2023/0591

30 Mortimer Road, Cubley, Barnsley, S36 9DF

Single storey rear and front extensions

PROPOSED FRONT (EAST) ELEVATION
1:100

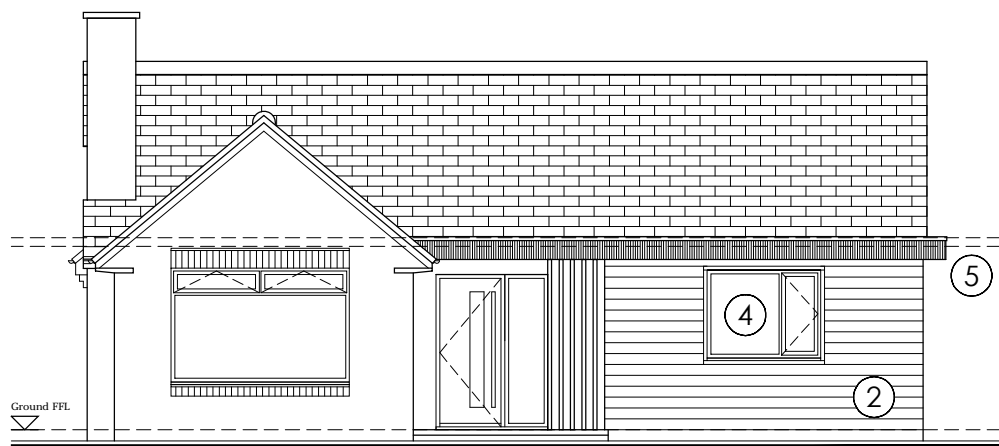
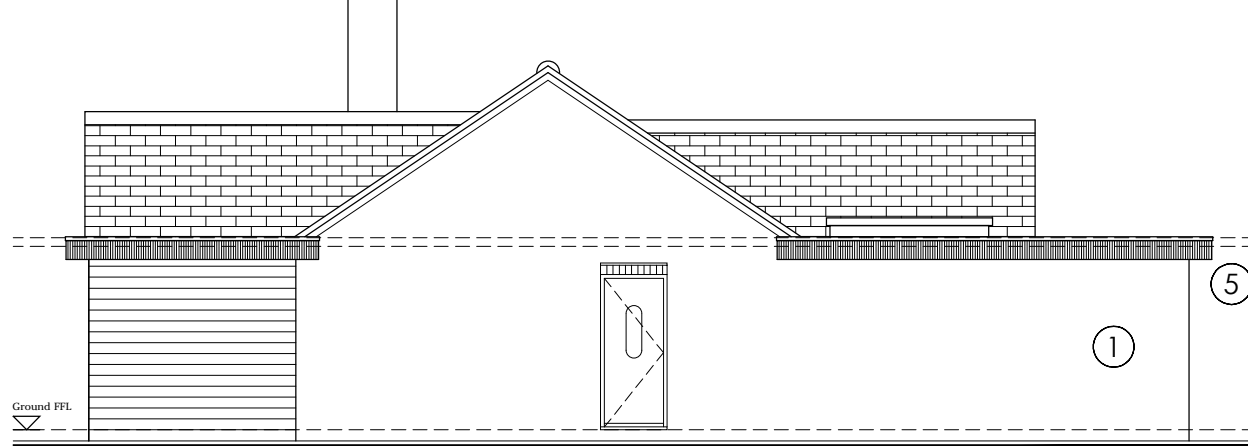
The applicant is seeking approval for the erection of single storey front and rear extensions. The front extension will project 2.75 meters from the front elevation of the dwelling. The extension has a width of 6.75 meters. The extension will feature a flat roof with a total height of 2.8 meters and an eaves height of 2.5 meters. The materials used will be cedar cladding.

The SPD states that *'materials should normally be of the same type, colour and texture to the existing house or as close a match as possible'*. In this case, the proposed materials for the rear extension will be matching brickwork and cedar cladding for the front extension. The cladding to the front extension although not a matching material will not be significantly harmful to the character of the dwelling as the majority of the dwelling will be retained as brick.

The street scene of Mortimer Road features a mix of materials including brick, various types of render and stone. Therefore, the addition of cladding is not deemed significantly harmful to the visual amenities of Mortimer Road given it will be set next to a neighbouring dwelling (28 Mortimer Road) featuring pebble dash render which therefore deviates from the existing design pattern of the run of bungalows the host dwelling is set within. The property is also set back from the road and has trees/vegetation to the front thereby providing some existing screening of the frontage of the property therefore minimising the impacts further

The proposal includes a front extension, and the front elevation is the most important elevation for its impact on the character of the street scene. The size of front extensions needs to be as modest as possible. There are no examples of similar front extensions in the street scene however the extension acts as infill to the existing front elevation and therefore would not create a standalone front elevation which would appear more alien. The size of proposed extension is acceptable, it complements the dwelling's character and doesn't detrimentally affect the street scene.

PROPOSED REAR (WEST) ELEVATION
1:100

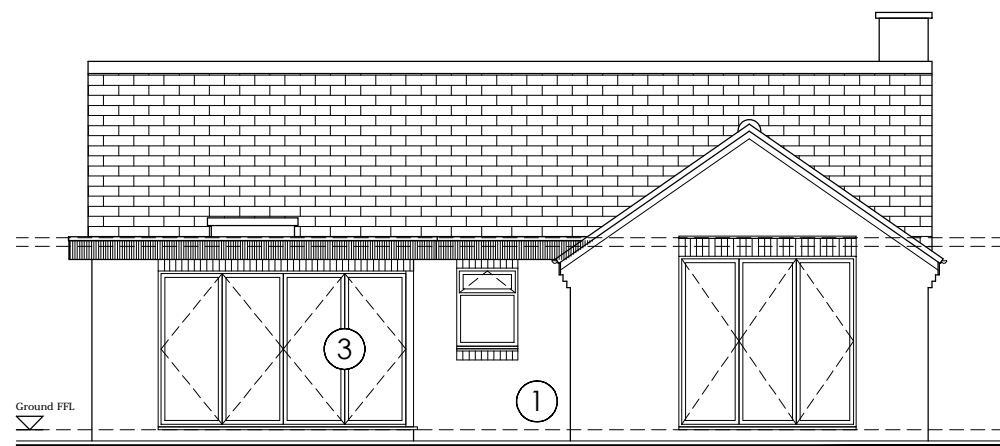
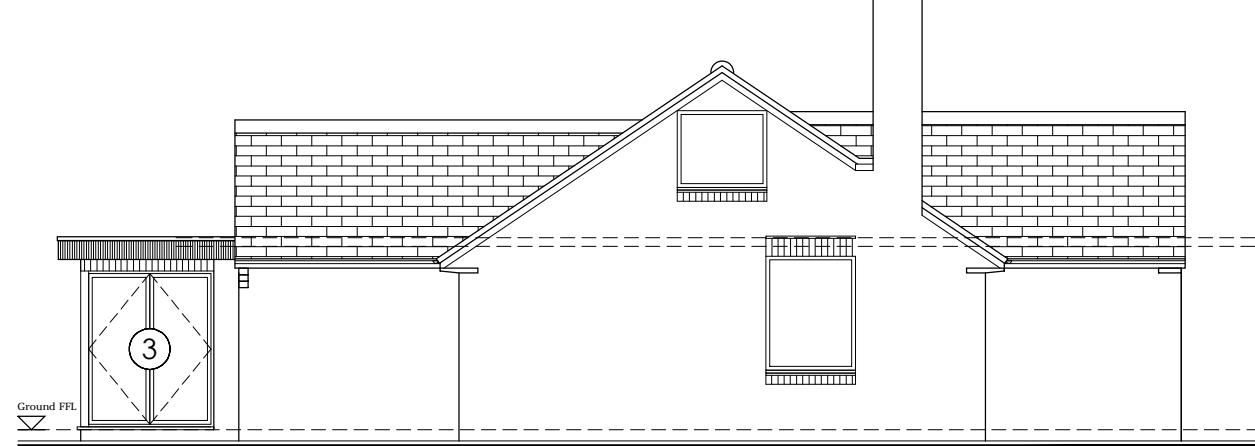
The rear extension will project 2.35 and 5.75 meters from the rear elevation of the dwelling. The extension has a width of 6.35 meters. The extension will feature a flat roof with a total height of 2.8 meters and an eaves height of 2.5 meters. The materials used will be matching brickwork.

The SPD states that *"extensions to the rear of detached houses will be considered on their design merits where no adjacent properties are affected"*. The proposed extension will not have a significant detrimental impact on any neighbouring property by way of overshadowing or being overbearing. In terms of overlooking the patio doors proposed on the side elevation are not deemed to cause a significant increase in levels of overlooking. The proposal is considered to be in compliance with Local Plan Policy GD1: General Development and is acceptable in terms of residential amenity.
